**CITY OF PORTLAND, MAINE  
DEVELOPMENT REVIEW APPLICATION  
PLANNING DEPARTMENT PROCESSING FORM  
DRC Copy**

Marlborough Rd. Lot # 34  
Project Name/Description

February 4, 2004

RE: Application for Single Family Developments,  
Marlborough Rd., Lot 1 (CBL#406F029) (ID#2004-0010)  
Marlborough Rd., Lot 3 (CBL#406F034) (ID#2004-0009)

EXISTING CONDITIONS SITE PLAN
 LOT 3 MARLBOROUGH ROAD PORTLAND, MAINE

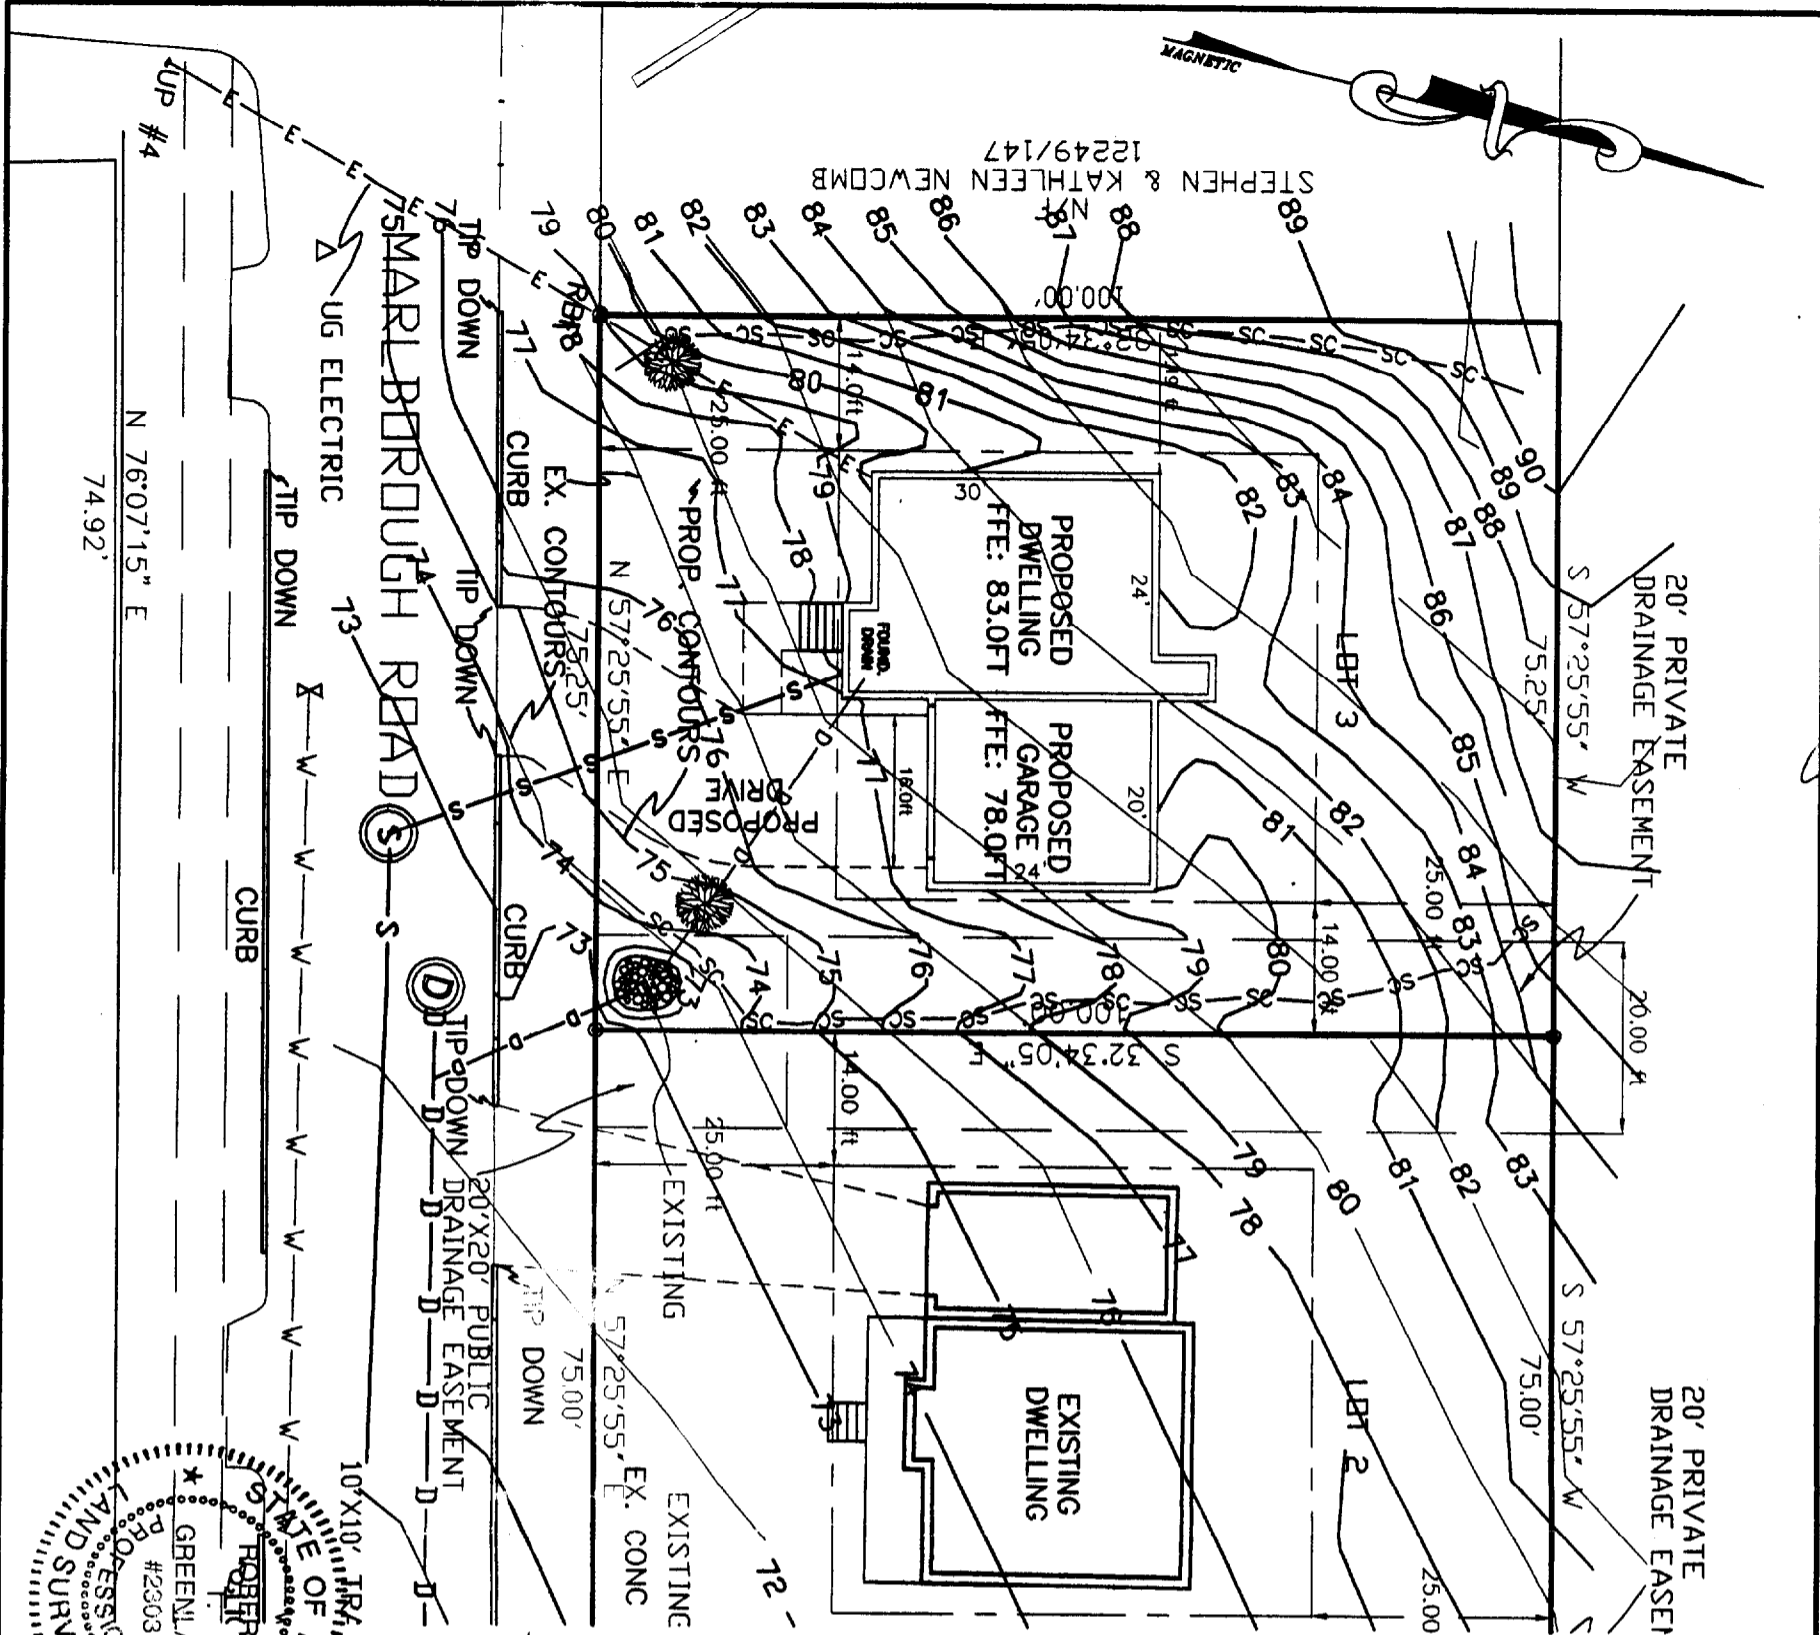
1. The Curbing, Curb tipdowns, and other right-of-way features are not shown correctly on the site plan. Please correct.
2. The proposed contours should wrap around the building to ensure drainage will be collected away from the foundation.
3. Please add erosion control to the site plan.
4. Please add a note to the site plan stating that the construction of the swale (within the private drainage easement) shall be coordinated between both property owners.
5. Please show, if any, the proposed foundation drains and outlets.
